Subject: Y/61/22/HH - PROPOSED EXTENSION TO POTTING BARN, NO 5 HOBBS COURSE, BILSHAM ROAD, BN19 0JY

I write to lodge objection to this planning application. The core of the objection is that this proposed extension would be over-development and would set significant precedent.

DRAWING
**HOUSE
PLAN
PROPOSED**

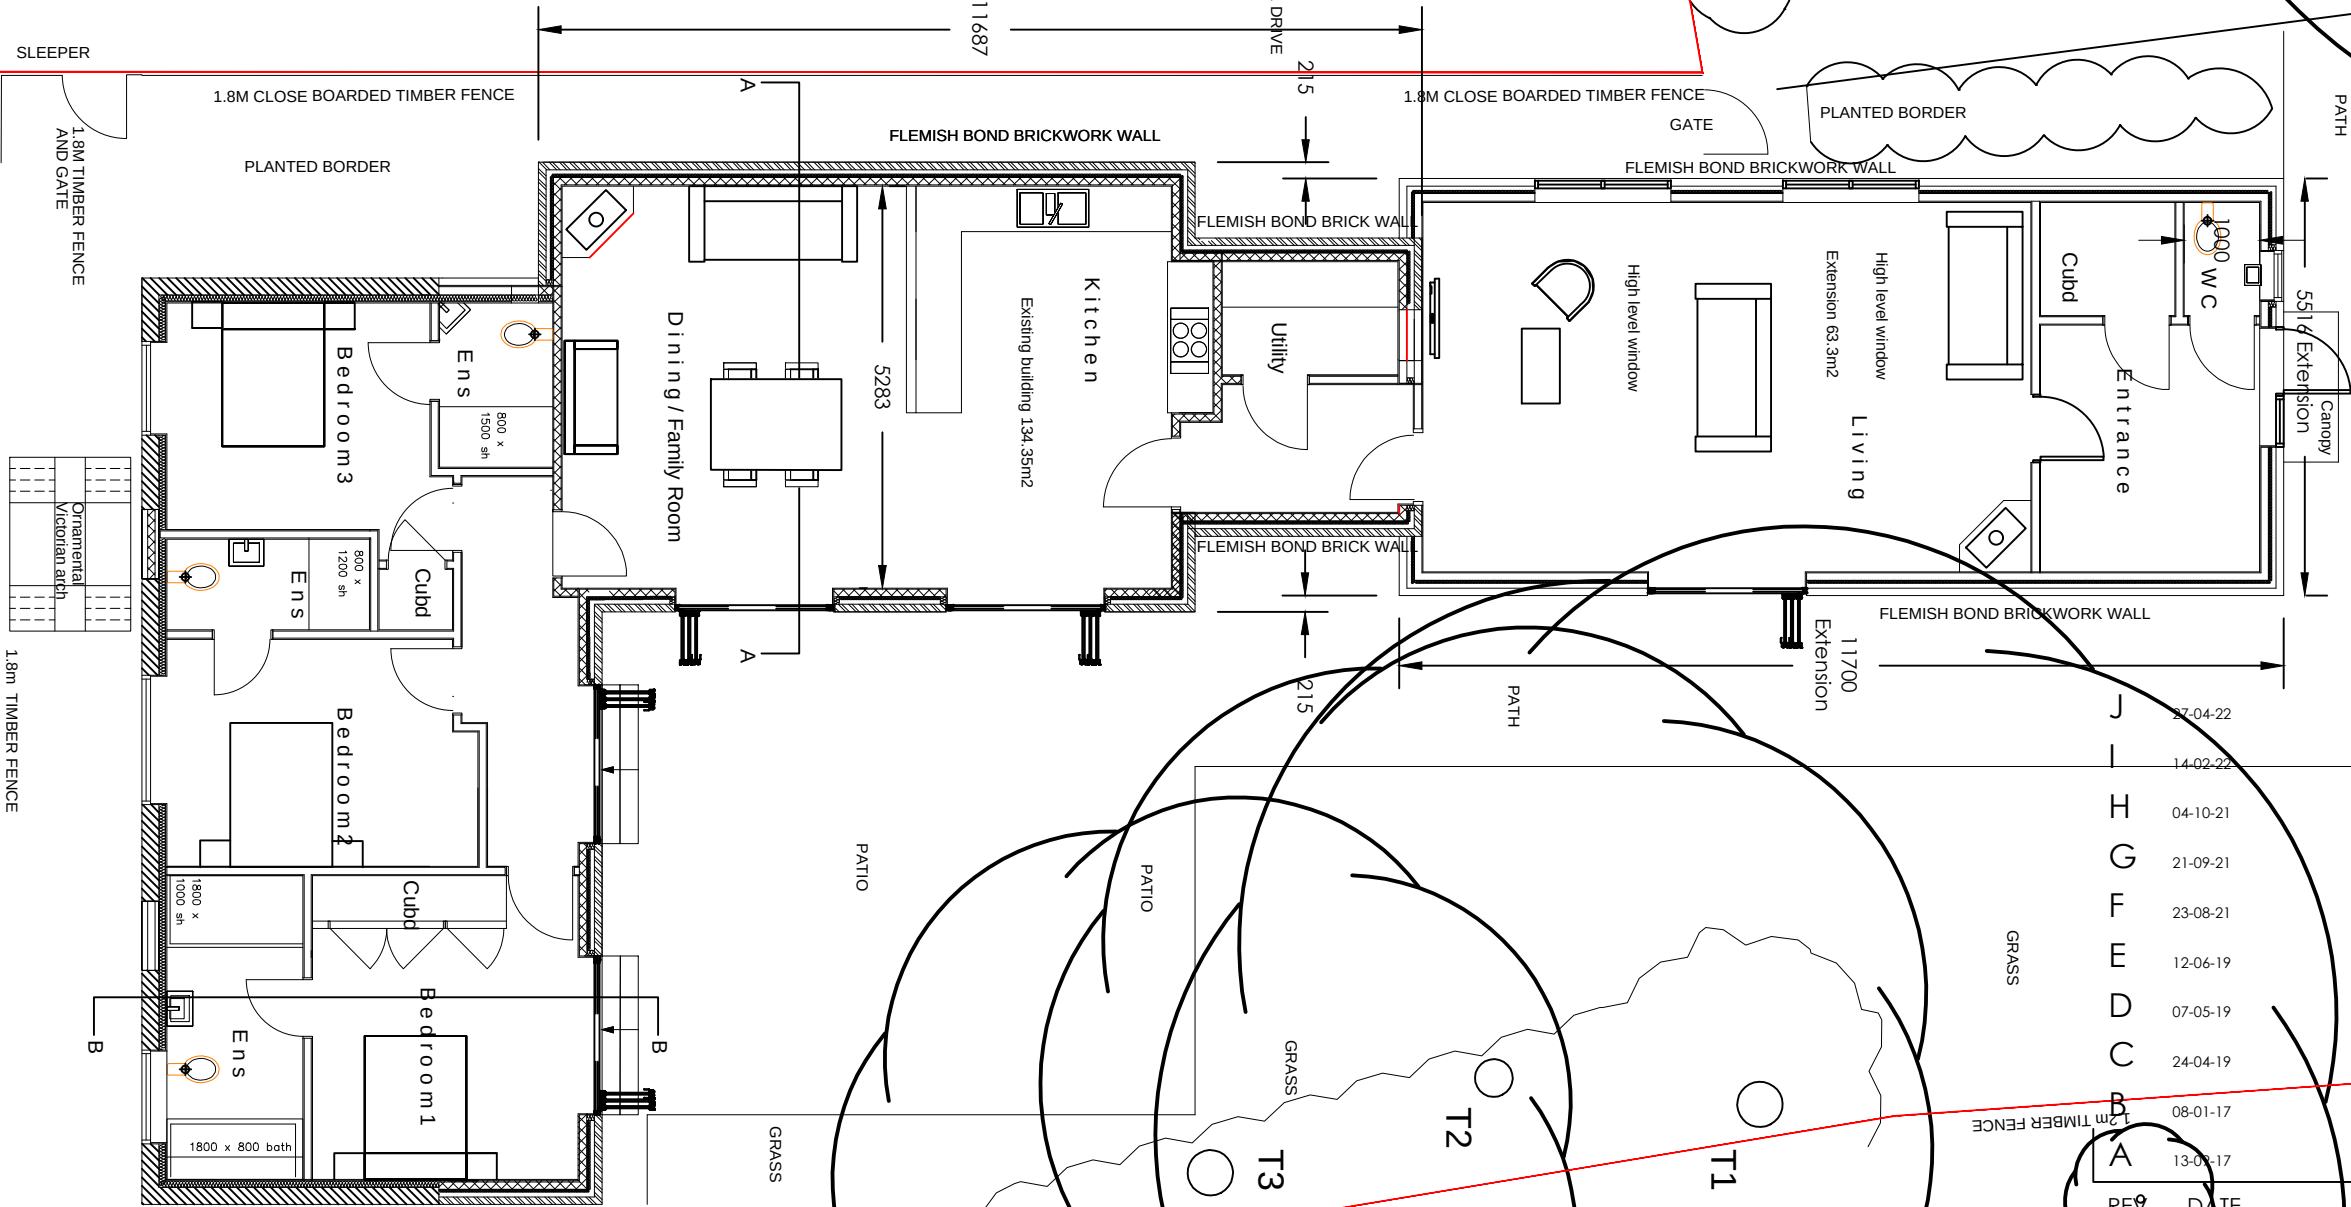
This proposal would add a further 199m² GEA (an increase of 61% from the current building, and 375% on the original) (It is suggested the at the figure on 47% increase in the application statements be re-checked) We appreciate the planning proposal follows on from a pre-ap submission and reflects subsequent planning department advice and that the original proposal to extend on a more ambitious plan has been scaled back. However, working on percentages of footprints, this proposal does look excessive.

We also note that the proposed layout shows an extension to the existing hardstanding to with 1.8M of our boundary and that the primary living space (with fully retractable bi-fold doors) will face directly onto our boundary and amenity space, approximately 7M away.
